Tuck O'Brien
City Planning Director, Planning Division

June 8, 2017

Project Name:	Hotel Redevelopment	Project ID:	2017-077
Address:	1210 Brighton Avenue	CBL:	265 A 1
Applicant:	Portland Hotels, Inc.		
Planner:	Nell Donaldson

Hotel Redevelopment
1210 Brighton Avenue
Level III Site Plan Review
2014-220
Portland Hotels, Inc., Applicant

Sheet Title:  
**Post Development  
Drainage Plan**

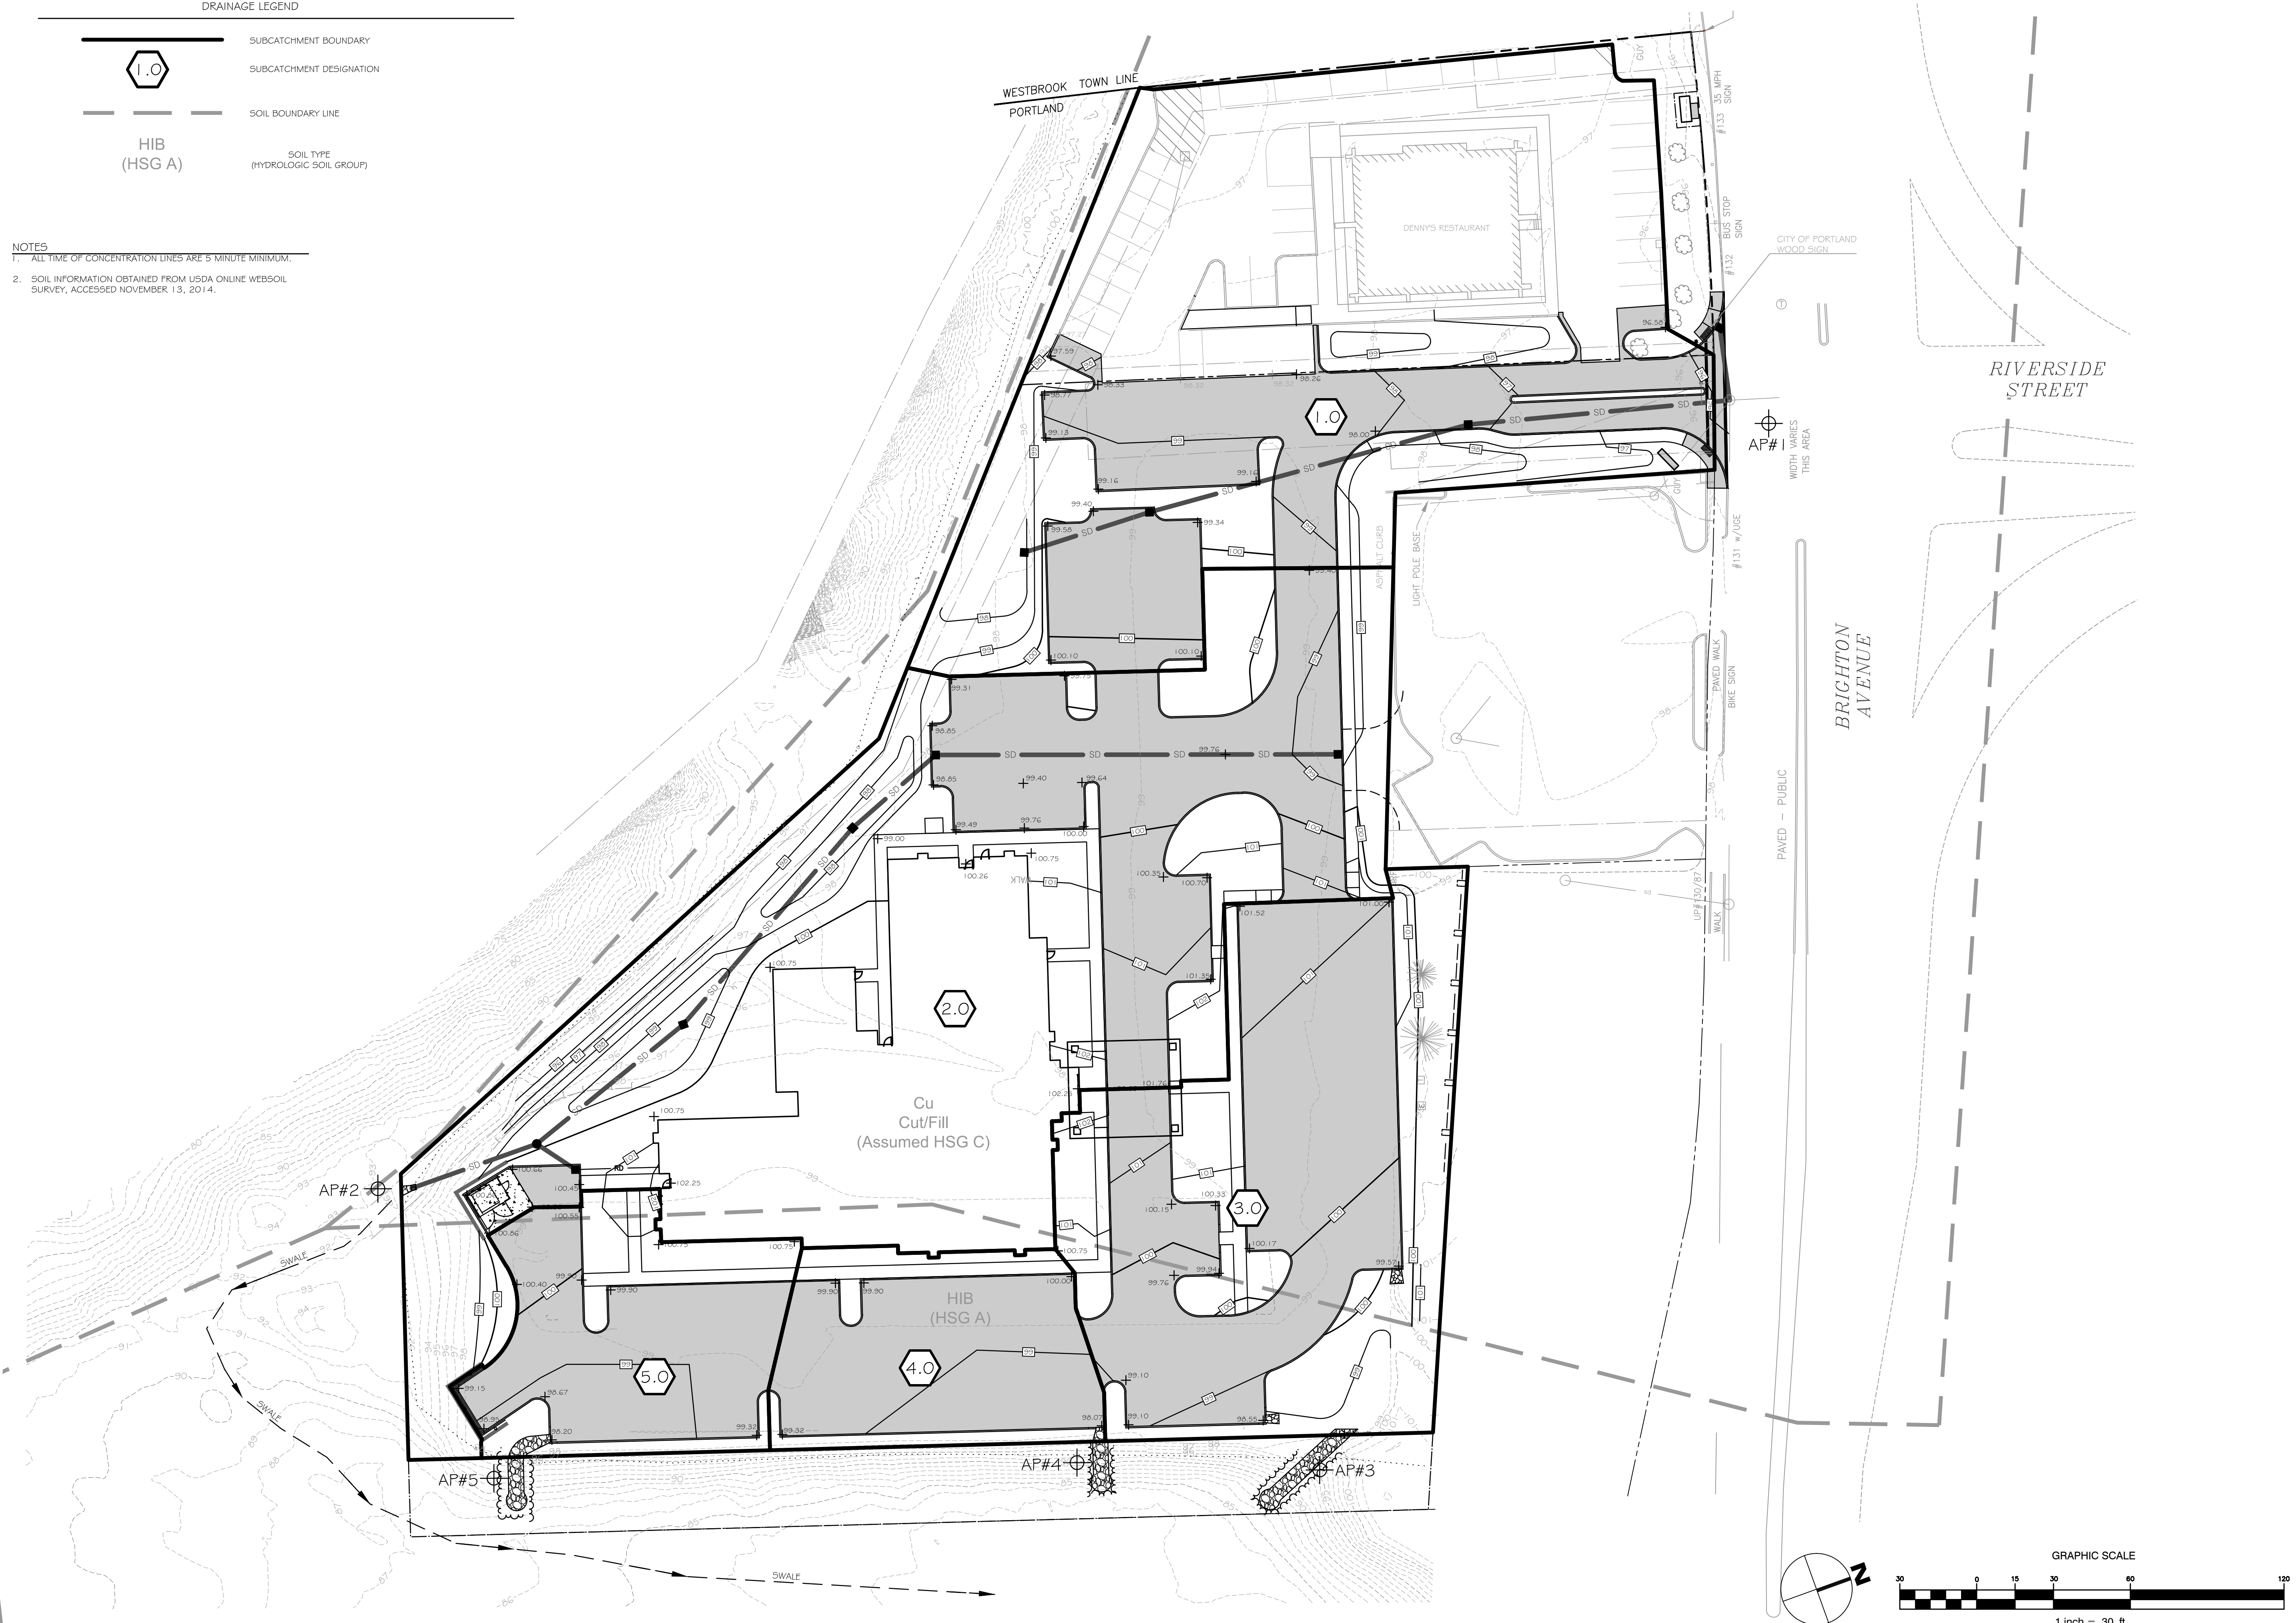
4. The applicant shall provide documentation, in both written and photographic form, of the condition of the stormwater outfall labeled AP#2 on Sheet D2.0 and provide design details for any additional stabilization measures required, to be reviewed and approved by the Department of Public Services;

A stormwater outfall proposed on the southern portion of the site (AP#2 on sheet D2.0) discharges to an existing swale within a CMP easement. The Applicant proposes a riprap apron at the pipe outlet. We recommend that the Site Plan approval include a condition requiring that the Applicant's engineer inspect the stormwater outfall AP#2 on Sheet D2.0 and provide a written description and photographs of this outlet, along with any additional proposed stabilization measures as determined necessary for review and approval by the City. Walsh Engineering Associates has stated that they will assess and document the condition of the outfall location once the snow has melted and will provide design details to the city for any additional required stabilization measures.
